**A1 Birtley to Coal House**  
**Scheme Number: TR010031**

**EXA/D4/007 Applicant's Comments on Submissions to**  
**Deadline 3**

**Applicant's Comments on Submissions to Deadline 3**

Fig 1. CNG Site (Shown in Red)

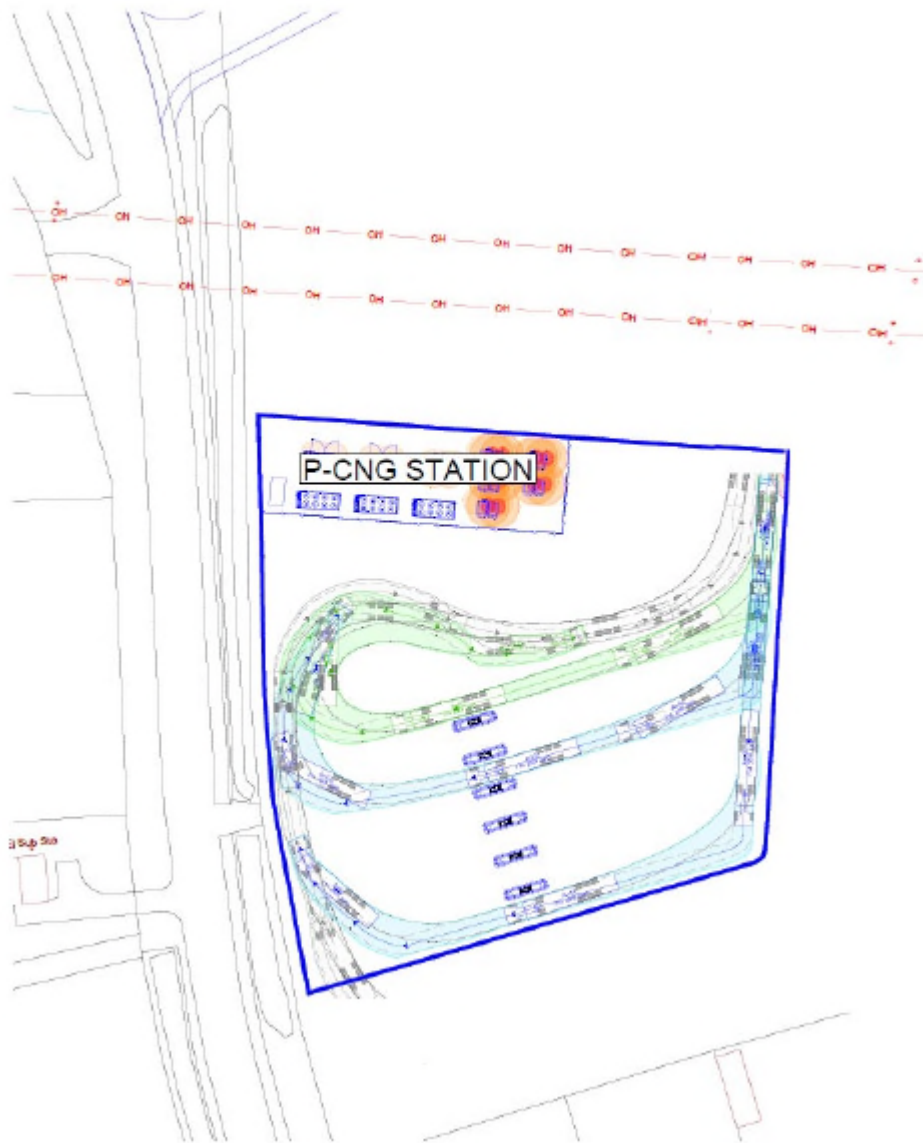
The Applicant is over-acquiring	19	This drawing shows the CNG Site as being occupied by a topsoil screening bund and a staff carpark. NGN does not consider that this drawing reflects the results of a detailed study of HE's requirements. NGN considers this drawing to be a rough schematic, which may not reflect the final use of the Works Compound. For example, it would be unusual if the land requirements for the Plant Store (I), the Material Store (J) and the Subcontract Store (K) were precisely equivalent, which they appear to be on this drawing. We also suggest that the positioning of a site office (which we presume would be installed by a crane) beneath a pair of high voltage power lines demonstrates the provisional nature of the drawing and a clear lack of care and consideration for the site compound, despite repeated objections to its use.	<p>The drawing which is described is an indicative drawing as the final layout will be decided by the contractor operating the construction compound, which is entirely normal in a scheme of this nature. It would not be proportionate to require the Applicant to demonstrate at this stage exactly how the construction compound will be configured when no technical details on the layout of the CNG station have been provided. Further, the CNG station is not itself sensitive to the layout of the construction compound. NGN is merely asserting that the size of the compound is excessive, which the Applicant considers – based upon expert advice – not to be the case.</p> <p>The use of the site is described in more detail as follows:</p> <p>The layout is likely to be as shown in Figure 1 of the Outline CEMP [REP2-051] with the following elements included within this compound:</p> <ul style="list-style-type: none"> <li>• General-The compound will be bounded by a secure perimeter fence with a gated access and manned security. There will be a part surfaced access route into and around the compound which will operate as a one-way system. The existing topsoil within the footprint of the compound will be stripped and temporarily stored as shown on the figure to act as a screening bund to Lamesley road and properties to the South of the compound. The compound will generally be covered with hardcore excepting parking areas which will be surfaced.</li> </ul>

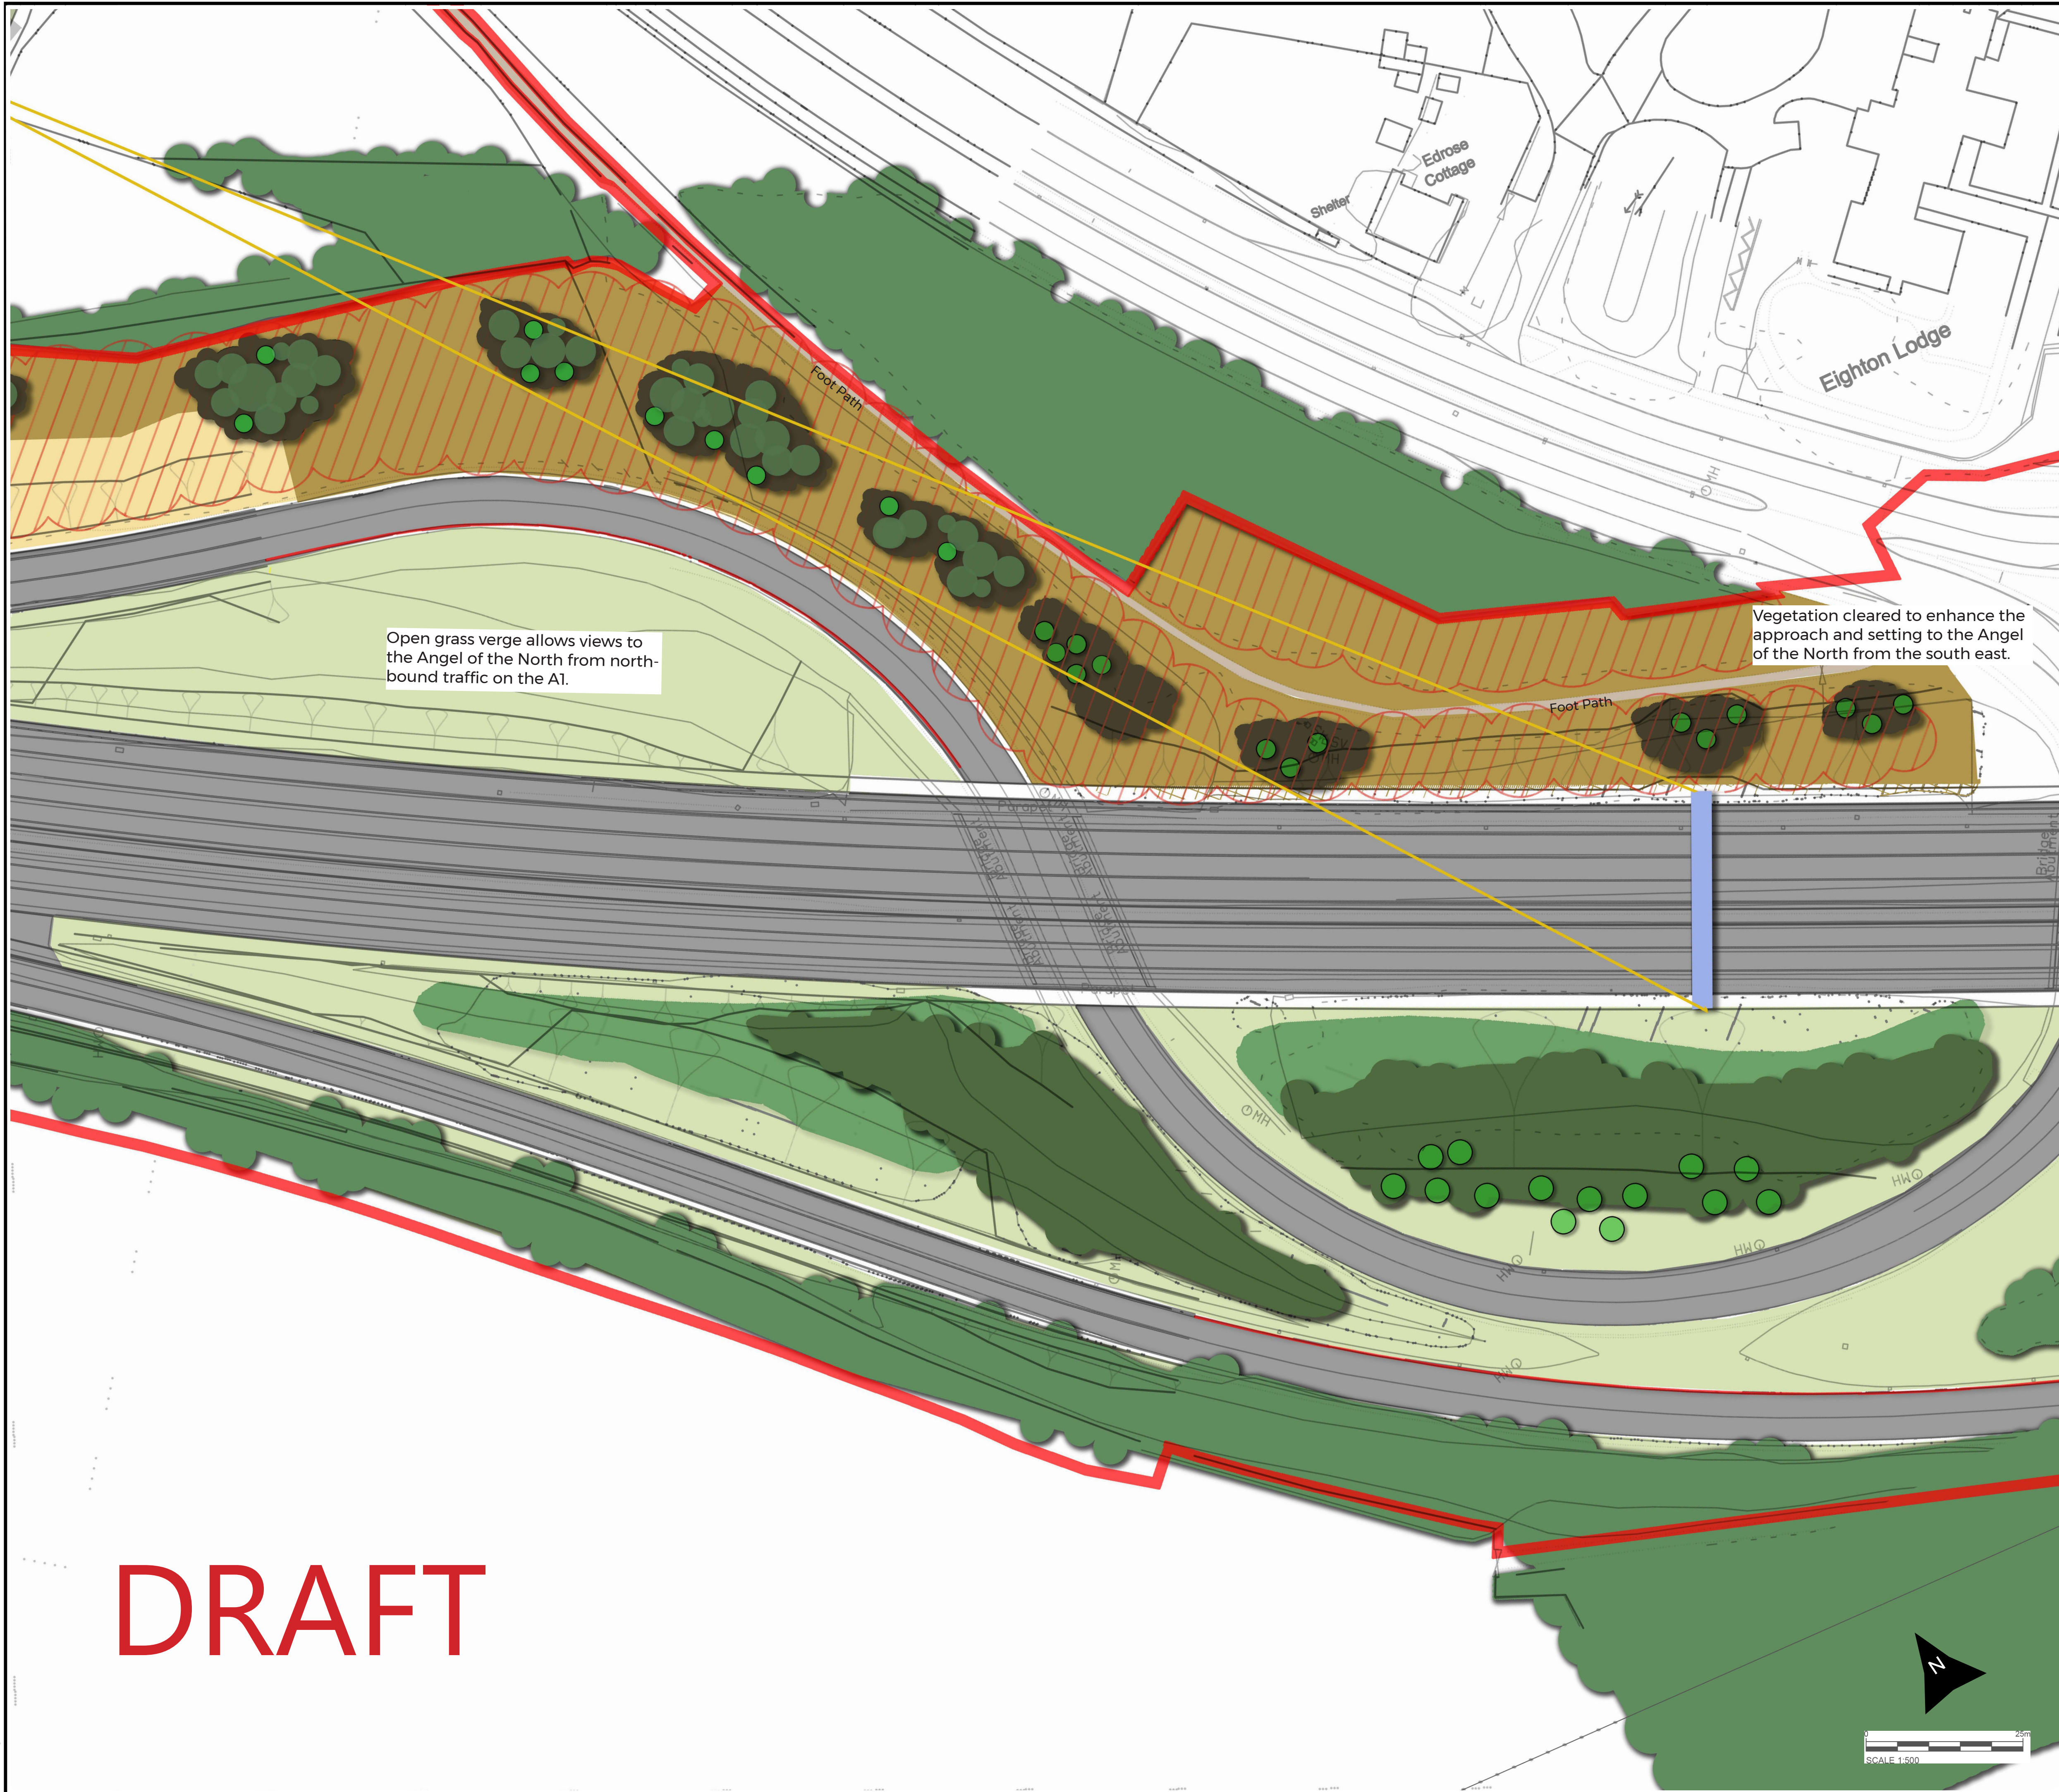
6	<p>Furthermore, it is extremely difficult to definitively comment on the gantries given that placement is still to be confirmed. However, we feel that the number of gantries, and in some cases gantries that span the entire width of the road, in the approach to the Angel of the North from the South on the A1 is significant.</p>	<p>The placement of the gantries is best understood through reference to the General Arrangement Plans [APP-010], these provide the locations for the gantries against which the assessment has been undertaken and graphic material prepared.</p> <p>As previously stated above, the number, placement, type, sign face design and structural form have been determined in accordance with Highways England's guidance at the time as set out in the DMRB IAN 144/16 'Directional Signs on Motorway and All-Purpose Trunk Roads: Grade Separated Junctions' which provides guidance on location of gantries and TD 18/85 'Criteria for the use of Gantries for Traffic Signs and Matrix Traffic Signals on Trunk Roads and Trunk Road Motorways' which</p>

Reference Number	Comment from Ella Bucklow on behalf of Antony Gormley Studio and Sir Antony Gormley	Applicant's Response
		<p>provides guidance on use of gantries. The main driver for the guidance in respect of gantry locations is the safe operation of the highway as explained in Appendix 2.0 x of the Applicant's response to the ExA's further Written Questions.</p> <p>Furthermore, the Works Plans [REP-038] (which show the authorised development for which consent is sought in the draft Development Consent Order [REP2-044 and 045]) show the locations of the gantries as areas that are hatched in orange on sheets 3 to 7. This means that the location and placing of gantries is restricted to those locations to adhere to the guidance outlined above. It is not the case that the placing of gantries is unrestricted, but rather a very limited amount of flexibility is permitted in order to respond to considerations such as <i>in situ</i> ground conditions. This means that there is sufficient certainty as to the design to enable accurate and robust assessment of the impacts of the gantries as part of the Scheme.</p> <p>As previously stated, the number, placement, type, sign face design and structural form have been determined in accordance with Highways England's. The main driver for the guidance in respect of gantry locations is the safe operation of the highway, and minor adjustment to the locations, within the parameters would not alter the findings of the expert assessment of effects undertaken.</p>
